29 January 2021

**Saint Ignatius' College Riverview Redevelopment Stage 2
Application Number SSD-10424**

Figure 6. Materials and Finishes (Source: PMDL Architects, 2020)

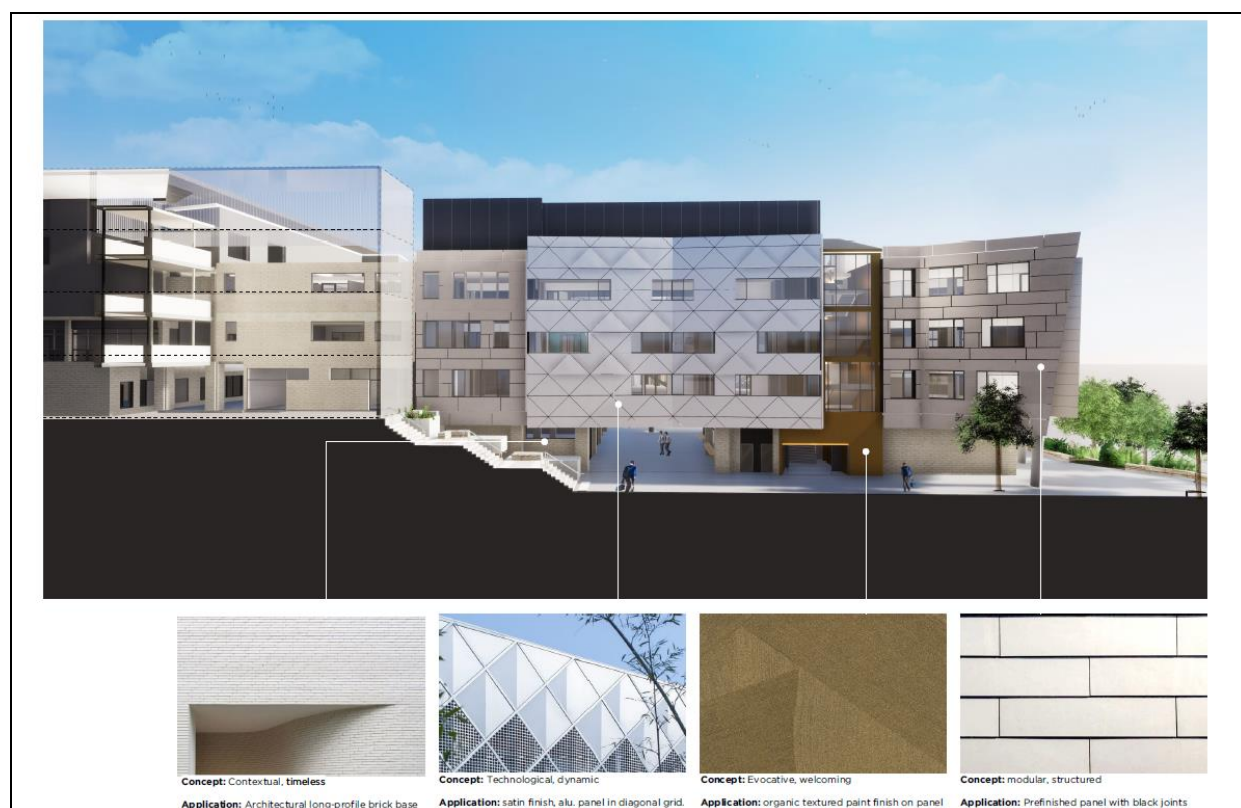
- The material selections proposed are contrary to the written text in the Site Analysis and Existing Building Material section of the report (p.11)
- Inelegant façade and proportions of the proposed design do not mitigate the building mass and bulk (and its understandably deep floorplate due to functions and pedagogy). There is a lack of rhythm in the façade proportions and subdivision that could take cues from the underlying rhythm of the traditional buildings on campus. Not in seeking to replicate the traditional but to analyse and understand the inherent design characteristics that these buildings possess and why they endure.

- This is exemplified in the relatively crude (over scaled and disproportioned) masonry reference in the cladding proposed.
- Any form of aluminum panel (either solid or composite) proposed for the façade or soffit is not supported. Under the current Australian Standards for testing façade panels & systems, there remains an inherent fire risk in locating (even if solid) aluminum panels located overhead egress paths and heavily student occupied zones. This risk requires very specific mitigation during documentation and construction phases.
